16th November 2020

Re: BR/244/20/PL

The Beach Hotel, former Mud Club Waterloo Square Bognor Regis PO21 1SU

Redevelopment into 11 No. 2 bed apartments & 2 No. commercial units (A1 Retail or A3 Restaurant/Cafe) (resubmission following BR/282/19/PL). This application affects the character & appearance of The Steyne, Bognor Regis Conservation Area & may affect the setting of listed buildings.

Project Title:	Date:
Waterloo Square, Bognor Regis	06.10.2020
Document Title:	Drawn by / Checked by:
Proposed Site Layout Plan	SR / GG
Drawing Scale / Sheet Size:	Client:
1:500 @ A3	B5 ltd
Drawing Status:	Drawing Number / Revision:
PLANNING	18.103.400

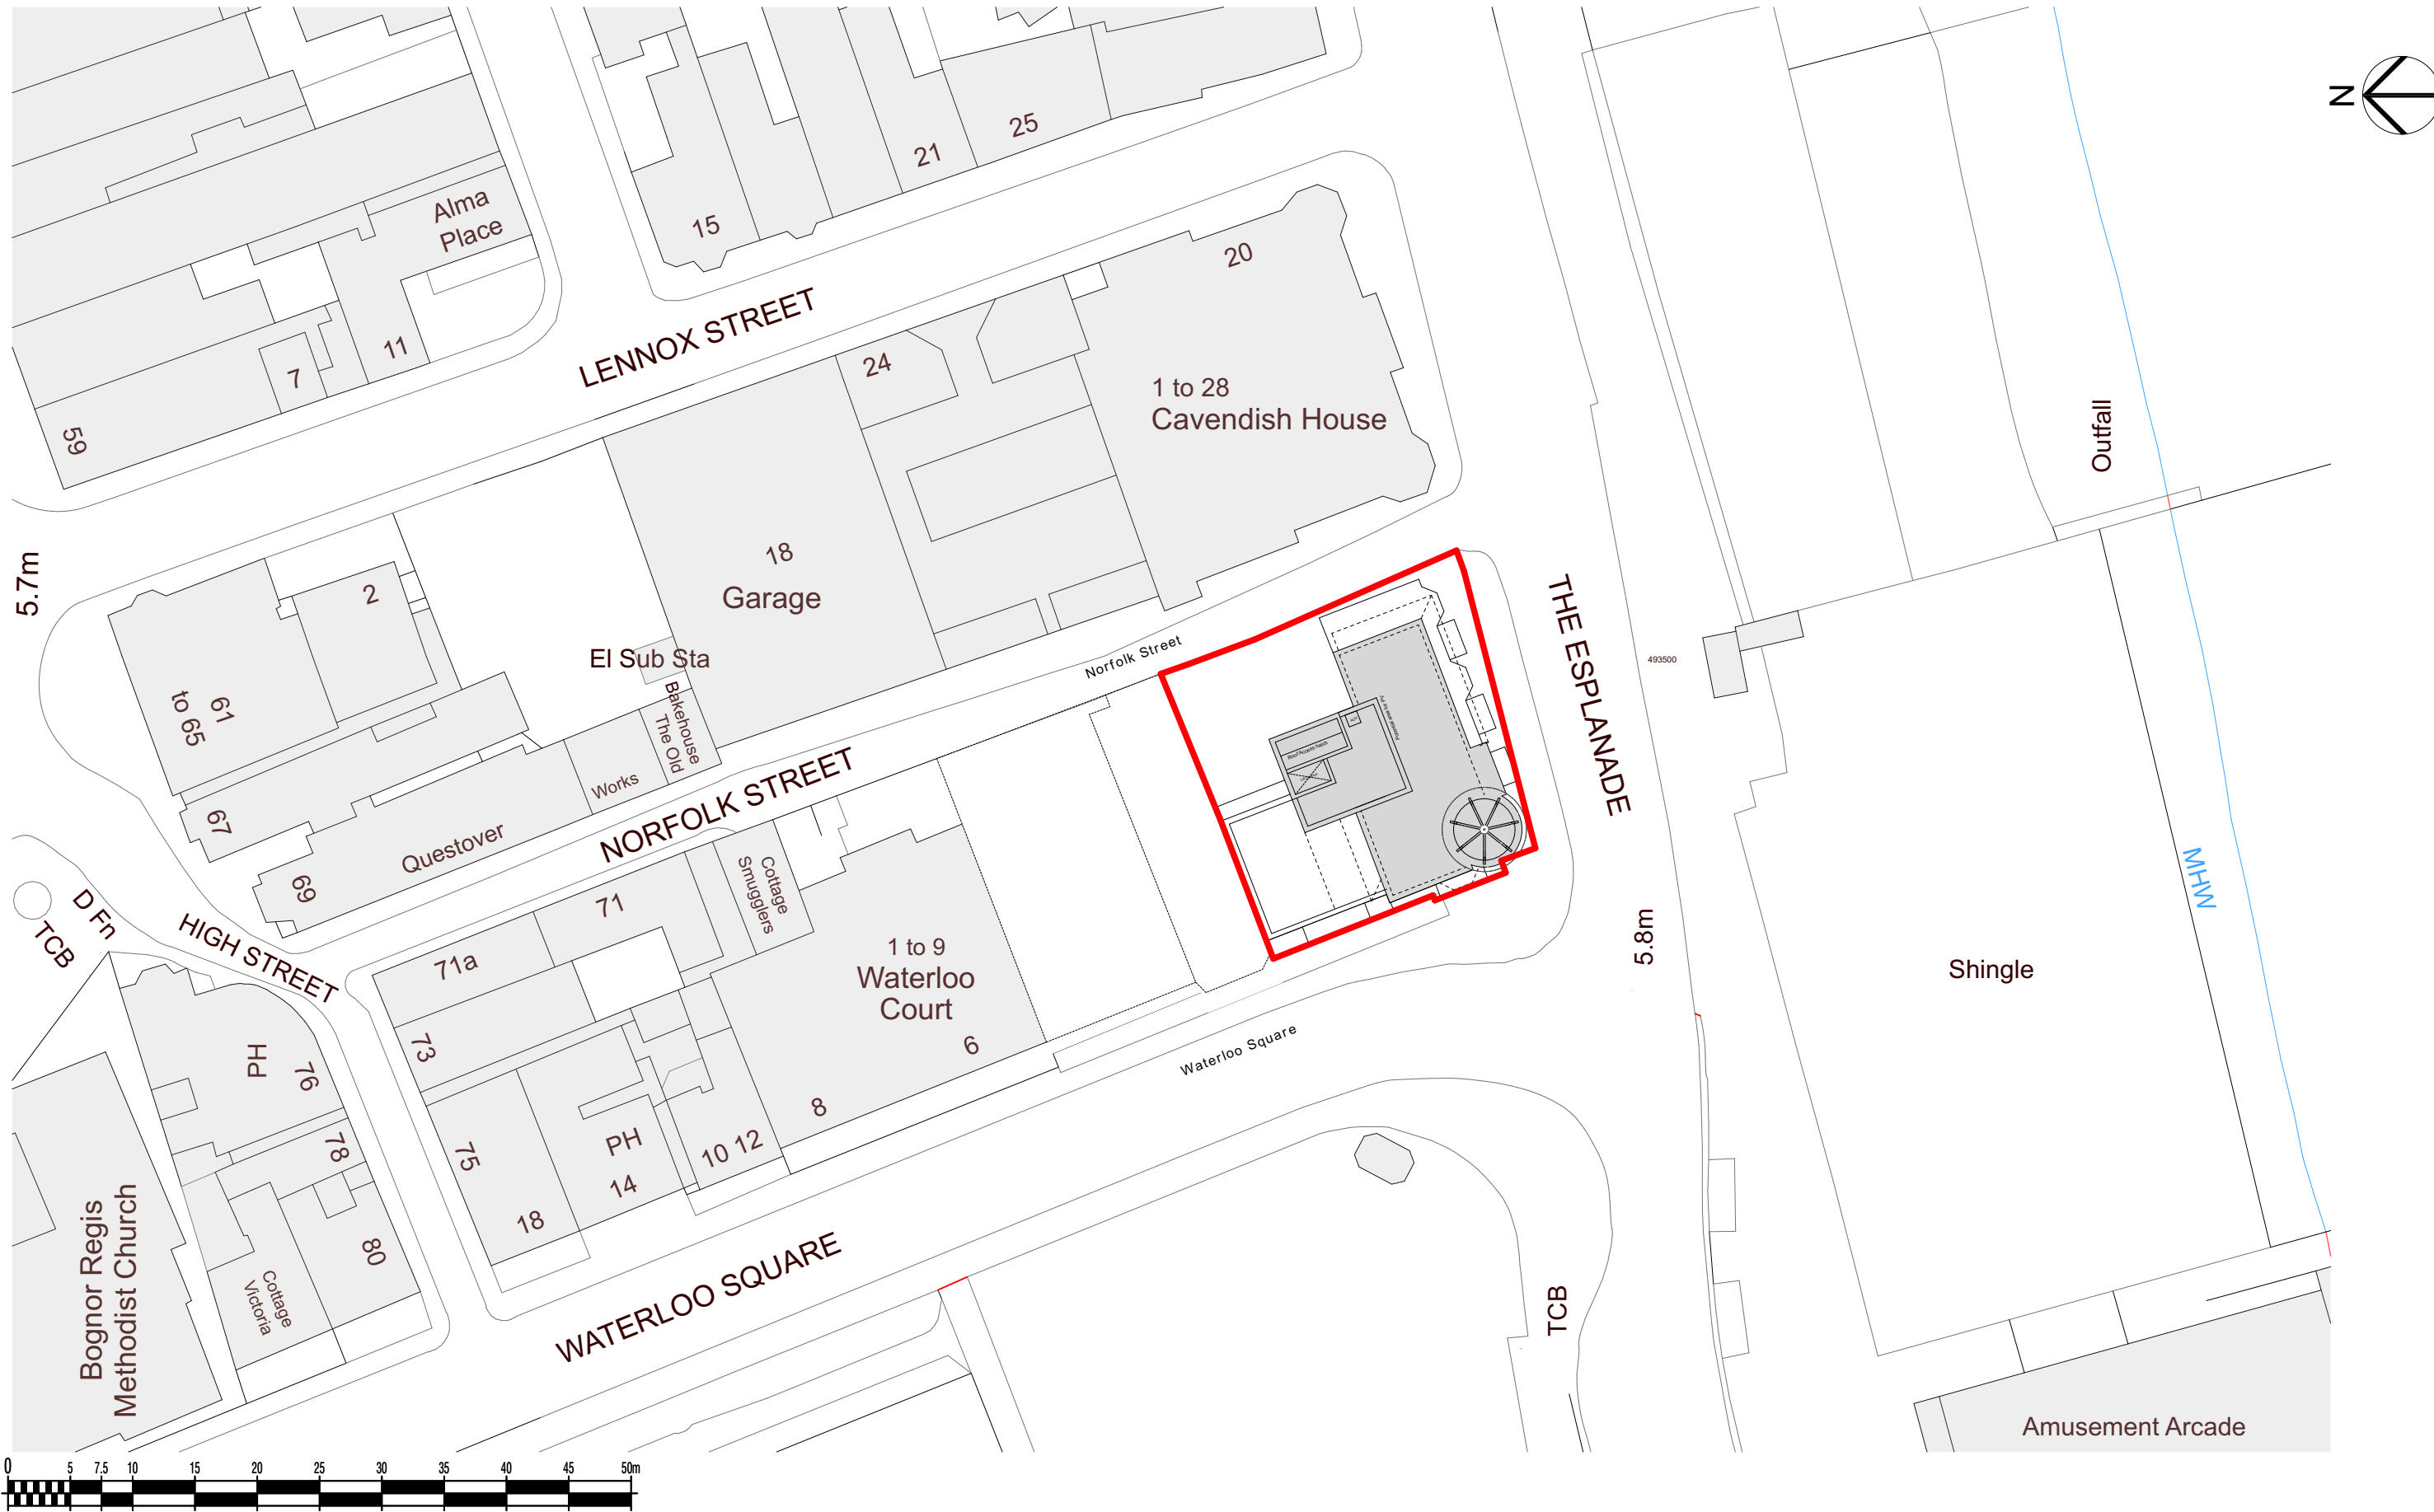
- The proposed application utilises only the original footprint of the now demolished Beach Hotel; the Board would encourage the applicant to come forward with a masterplan to illustrate the forward vision for Nos. 2 & 4 Waterloo Square and allow the current application to be assessed against the context of the whole site.

Document Title:
 Norfolk Street Elevation 3-3

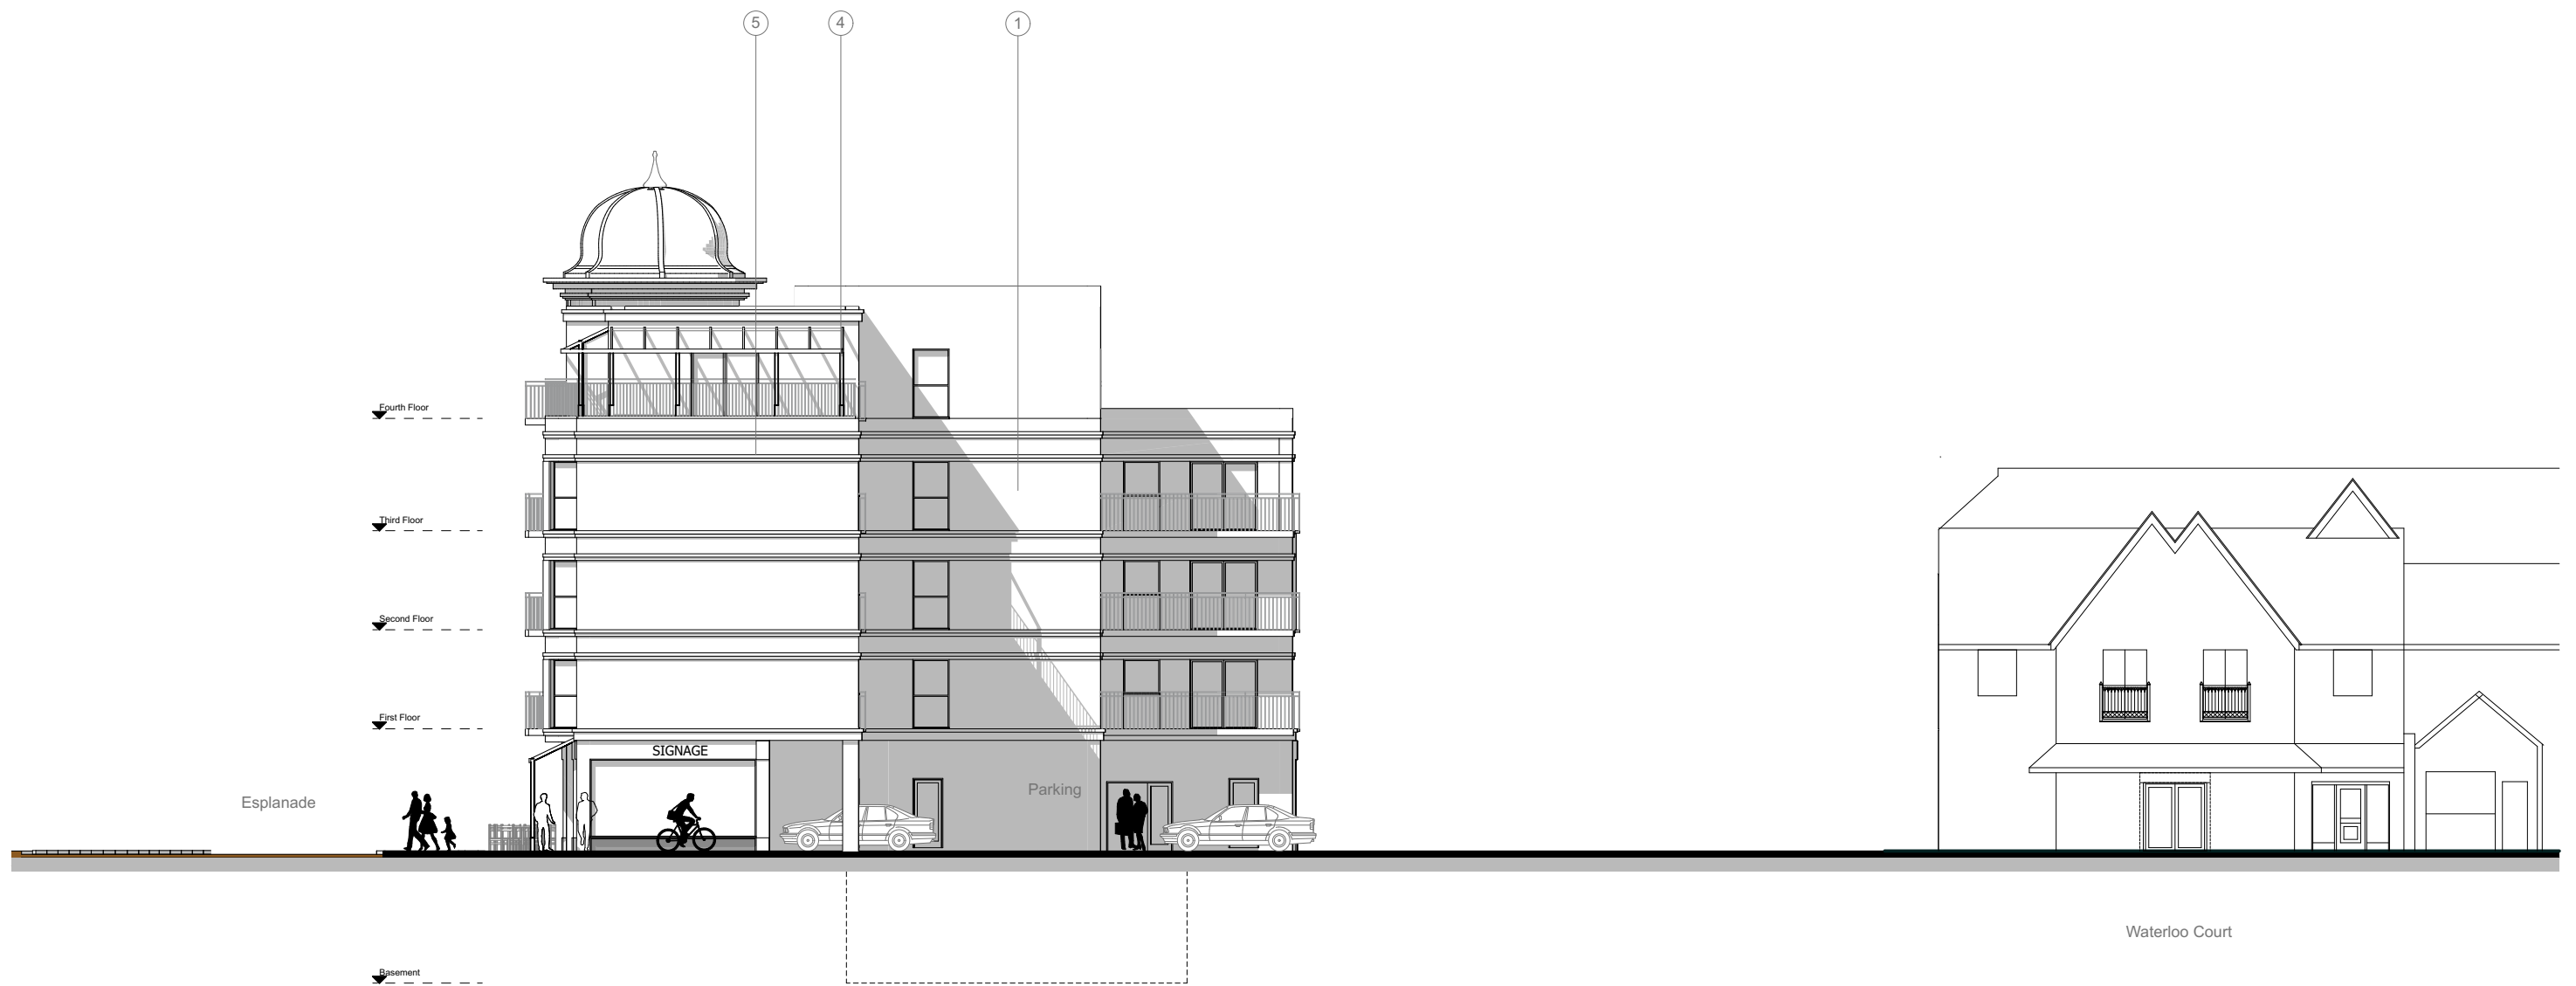
- The height of the proposed building, being at least 1.5 storeys higher than adjacent roof lines along The Esplanade and substantially higher still than those of Waterloo Square, is out of keeping with the local street scene and therefore does not respect the character and identity of the area nor does it integrate with the scale and proportion of surrounding buildings. Should the application be approved it would set a new precedent for building heights in the Old Town area which would not accord with the constraints of the Conservation Area or the principles outlined in the Bognor Regis Masterplan.
